**Environment, Planning and  
Enforcement**

15 February 2019

**Re: Application by RiverOak Strategic Partners for an Order Granting  
Development Consent for the upgrade and reopening of Manston Airport  
– Relevant Representation Summary**

Figure 9.4
Built heritage assets within the site boundary

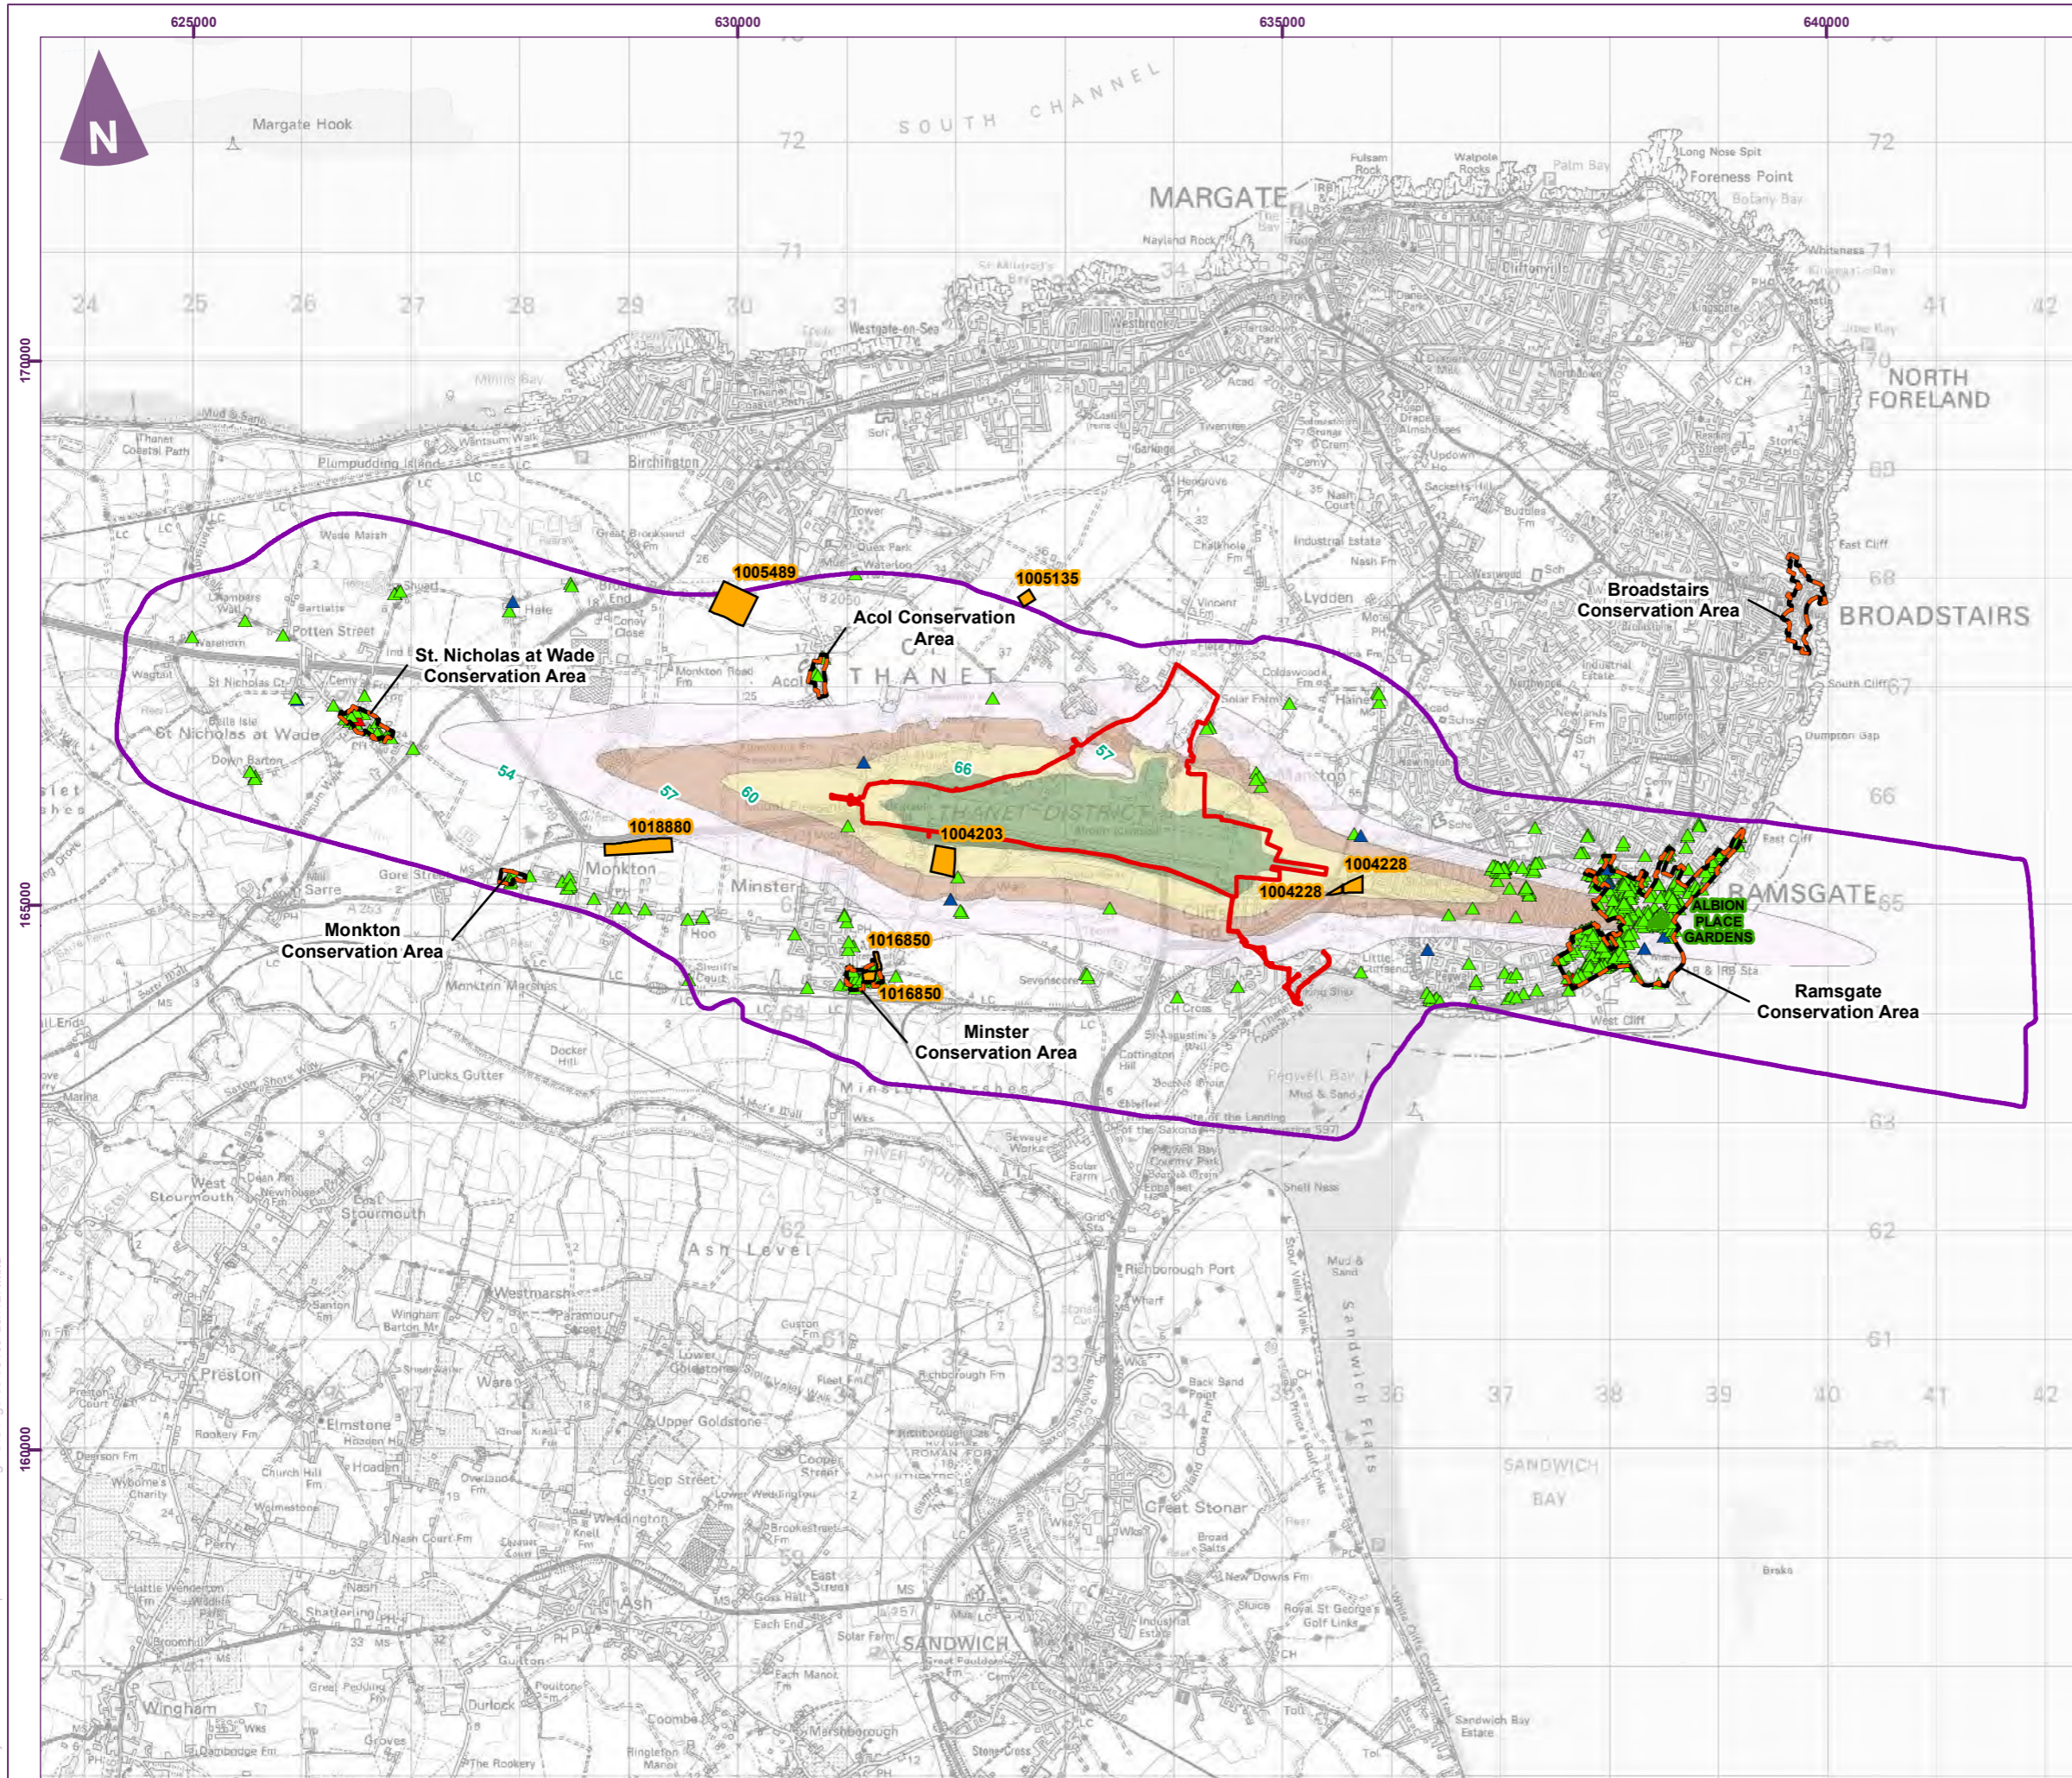
- Section 9.9 refers to Built Heritage assets within the site. KCC recognises the limitations that access to the site has caused in terms of surveying heritage assets. However, it is difficult to understand what will be unavoidably affected by the proposed development and what may be retained.
- The County Council welcomes the intention to retain the museums and memorial gardens and would support any enhancement opportunities that can be delivered. The connection of these to the built heritage in a holistic way to ensure the historic sense of place of the airfield is recognised and important. Demolition of historic structures should be avoided where possible.
